RE: Snowy 2.0 Exploratory Works Modification 1 (SSI 9208 – MOD 1)

ATTACHMENT A – Assessment Summary for Snowy 2.0 Exploratory Works Modification 1 (SSI 9208 MOD 1)

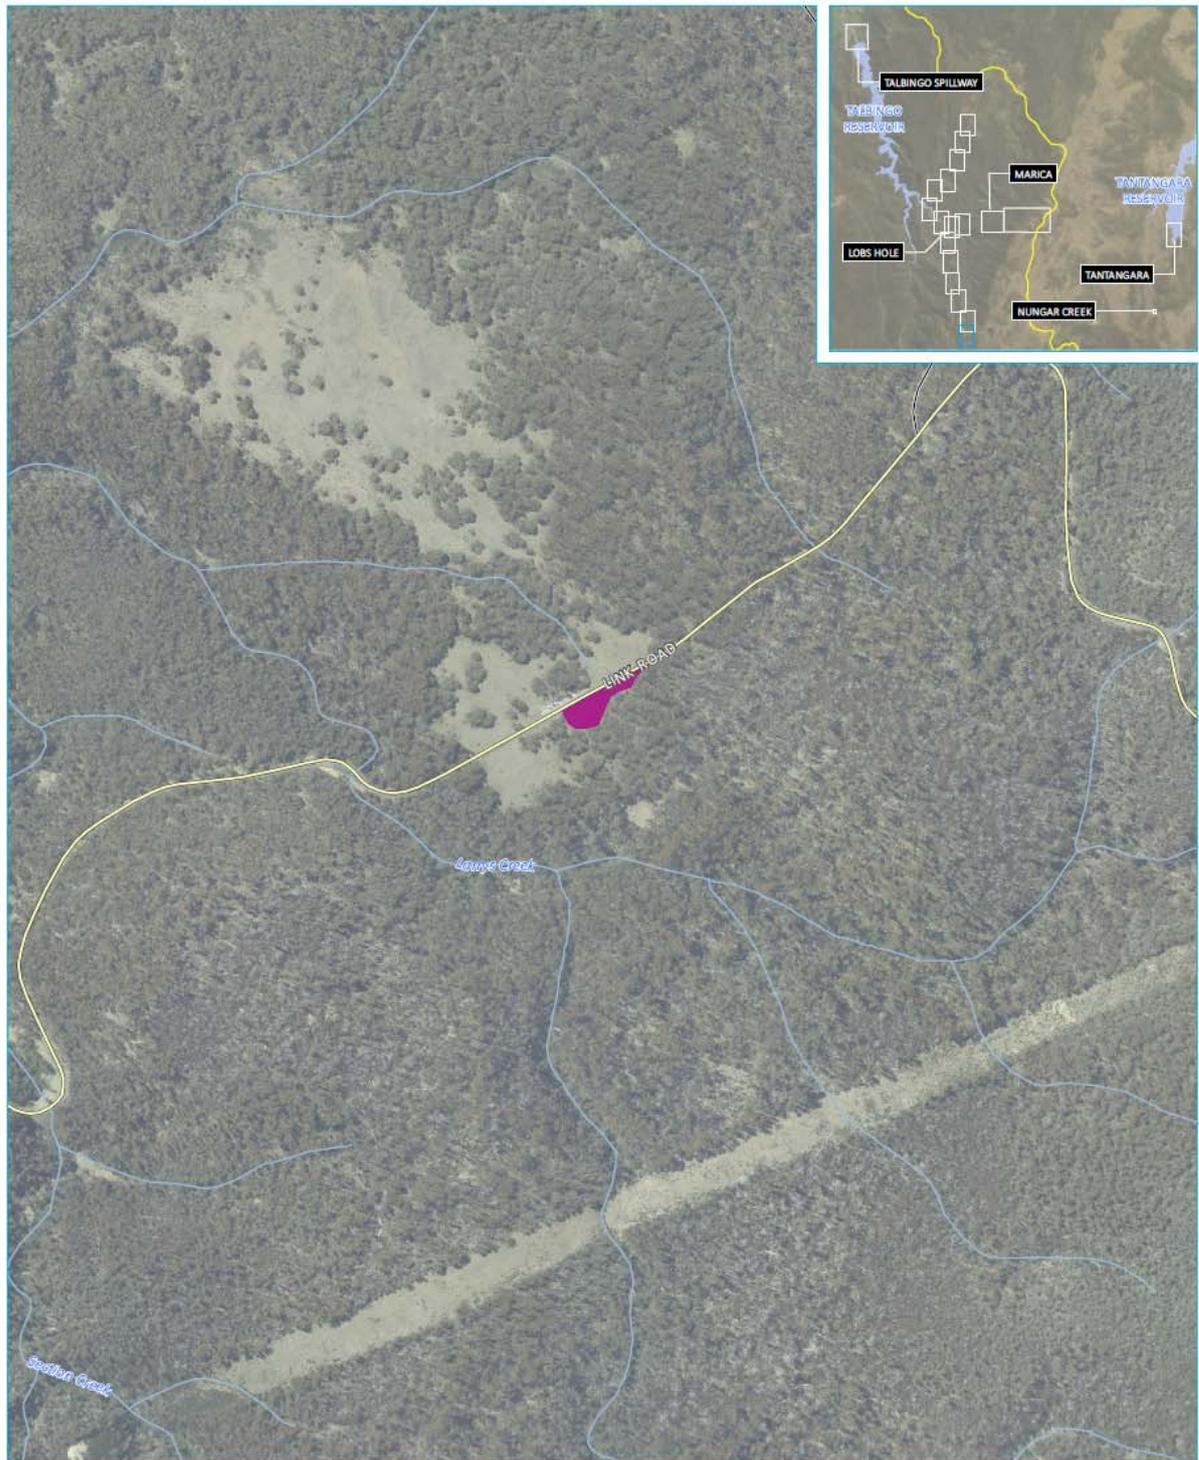
Another key issue is that the removal of the 91 trees along Lobs Hole Road has not been included in the offset calculations for the modification.

11	<i>Dangerous tree removal</i>	<ul style="list-style-type: none"> The BDAR and offset calculations do not include the 91 trees being cleared on Lobs Hole Road. Some of these trees are large and hollow bearing. <p>Recommended actions:</p> <ul style="list-style-type: none"> The offset calculation and the credit liability is to be adjusted to include the 91 trees. The financial amount payable in Condition 7 is to be adjusted accordingly. The offset strategy is to detail how the loss of hollow bearing trees will be offset on park. Clarification on the surveys for arboreal fauna and hollow dependent birds is to be provided including whether the 91 trees were assessed during the appropriate time for breeding habitat. Mapping and location of the 91 trees would assist in determining if the trees were surveyed. Where feasible, the impact of the removal of hollow bearing trees is to be mitigated by cutting out the section(s) of each removed tree with the large hollows and remounting them on suitable trees.

Figure 2-28: Road Upgrades – Boulder Streams – Lower Lobs Hole Ravine Road

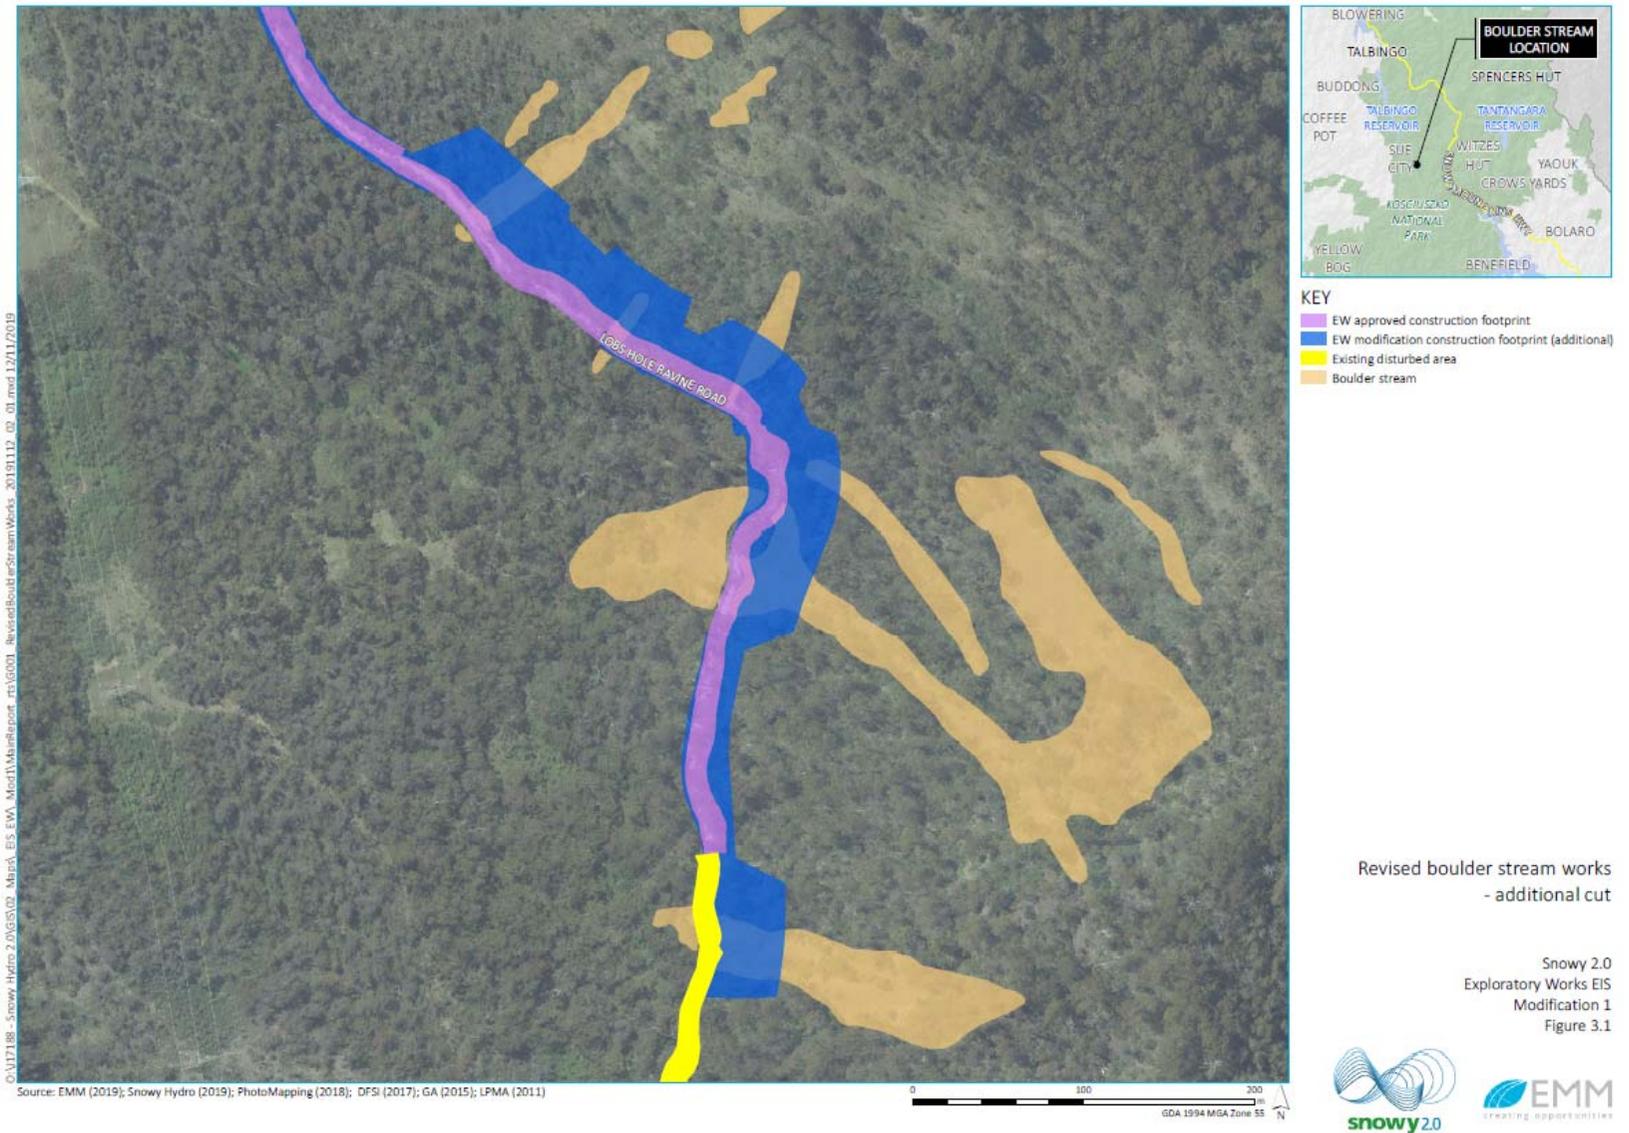
A significant concern discussed with representatives of Snowy Hydro Limited during the initial Exploratory Works assessment was the impact on geodiversity values. NPWS strongly recommends that damage to the boulder/stream screes and fossil beds in the upgrade of Lobs Hole/Ravine Road continue to be avoided as part of these Modification works.

<ul style="list-style-type: none"> The visual assessment (Volume 1 Section 6.5.5) states that visual impact assessment for the substation will not be done until the Main Works application. <p>Recommended actions/conditions of approval:</p> <ul style="list-style-type: none"> All feeder power to construction facilities are to be provided via underground cables. A visual impacts assessment is to be completed and assessed for the substation as part of this application. The current NPWS and Transgrid agreement, "<i>Procedures for the undertaking of Inspection, Maintenance and Emergency Works on Transgrid Network Assets and Associated Infrastructure 2014</i>" is to be referenced for all operational requirements of Transgrid facilities in KNP.
4	Changes to project boundary.	<ul style="list-style-type: none"> Changes to the project boundary do not include all access tracks, laydown areas and communication sites identified in the modification. An assessment of impacts has been carried out for road widening at the fossil beds. However, no assessment has been made for similar widening at the streams/boulder scree. <p>Recommended actions/conditions of approval:</p> <ul style="list-style-type: none"> Changes to the EIS boundary are to incorporate all areas identified in the modification. All works are to be incorporated and conducted as per the Exploratory Works Environmental Management Strategy and associated plans. All rehabilitation is to be incorporated into the Exploratory Work Rehabilitation Plan (yet to be developed) as per Condition of Approval 58. An independent significance, impact and geotechnical engineering assessment is to be undertaken of the proposed works at the stream/boulder scree. The mitigation measures identified in the RTS Volume 2 Table 3.2 relating to "no retaining wall" is a condition of approval. No impacts beyond those already approved are to occur to the stream/boulder scree and/or site of the Devonian strata fossil beds on Lower Lobs Hole Ravine Road.
